KITITAS COUNTY FIRE MARSHAL'S OFFICE

December 9, 2013

Re: Larson Fruit (CU-13-00007)

Upon review of the above mentioned land use action, I have the following comments/requirements;

SITE PLAN

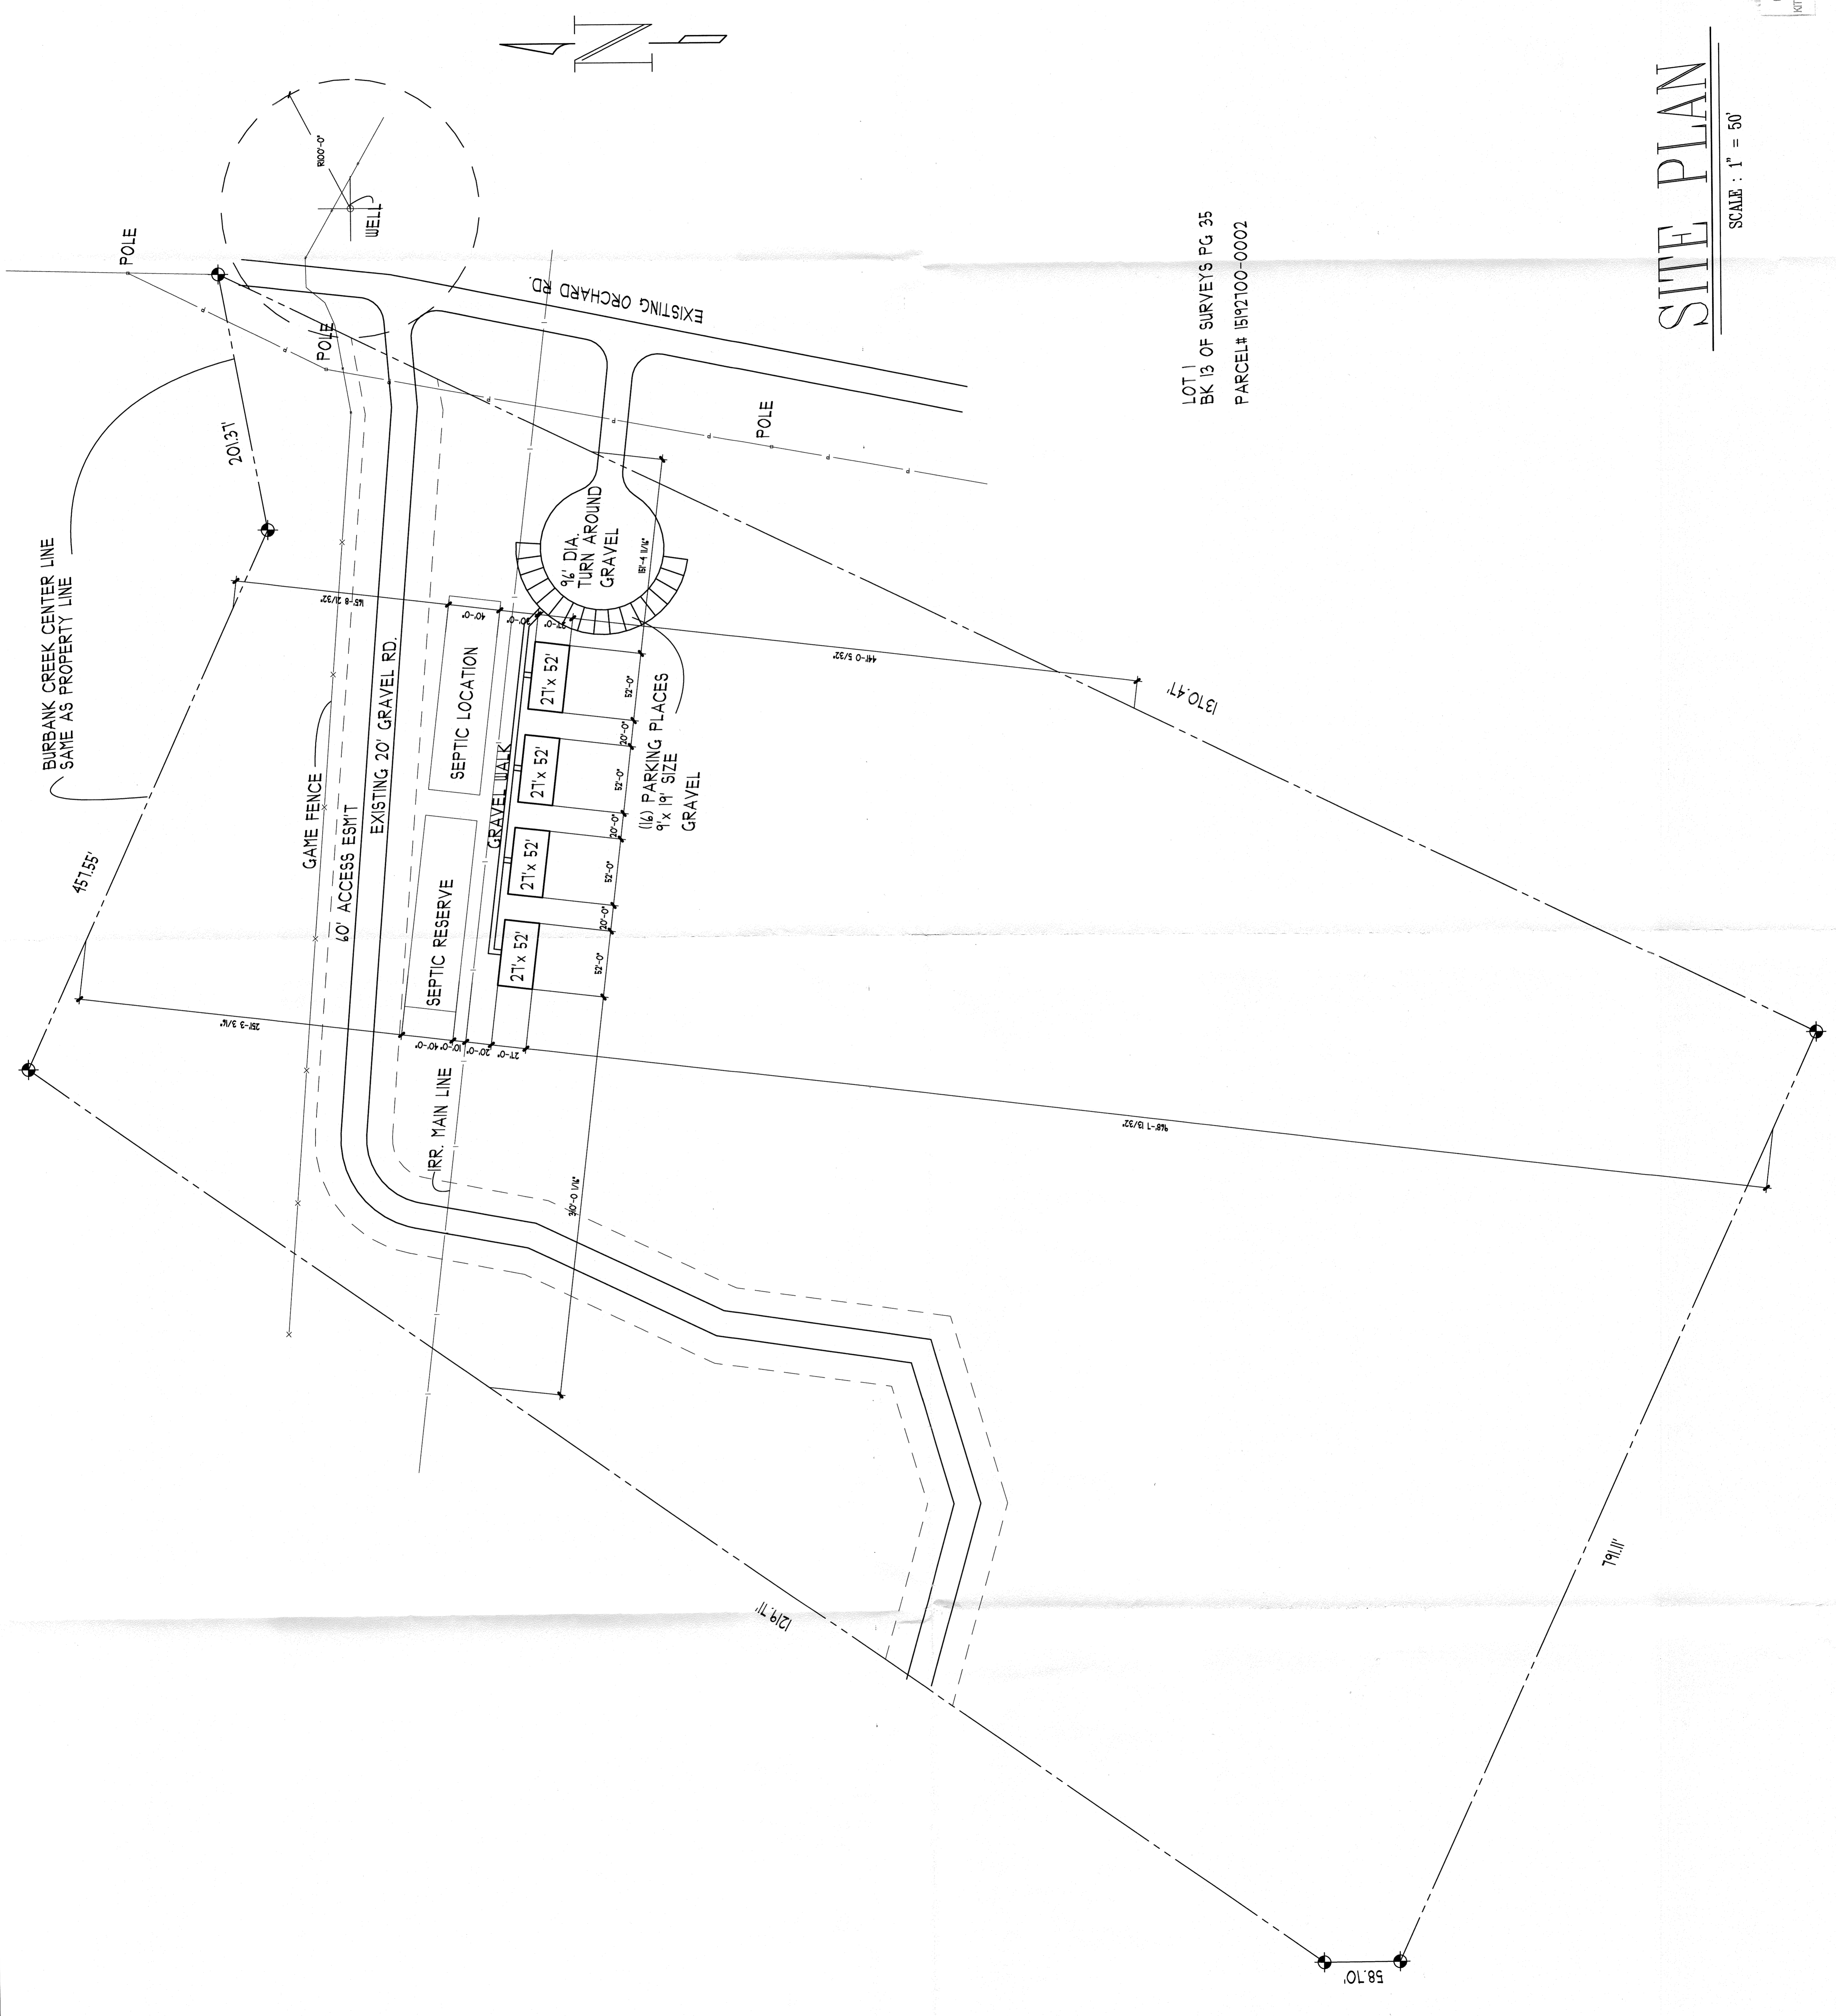
- A turn-around shall be provided for fire department access.
- A County approved blue reflective address marker shall be posted and maintained at the driveway to the structures and on each structure. The individual structures shall be assigned a number or letter by the project manager for emergency purposes, i.e Building 1, Building A, etc.
- The buildings may be no closer than 10' from each other.
- Submittal of a WUI application is required for this property as it is located outside of a fire district.
- Fire extinguishers shall be located appropriately. I can assist with this prior to occupancy.
- A fire and life safety inspection shall be conducted prior to occupancy.
- All development, design and construction shall comply with Kittitas County Code, Kittitas County Zoning and the most current version of the International Fire & Building Codes.
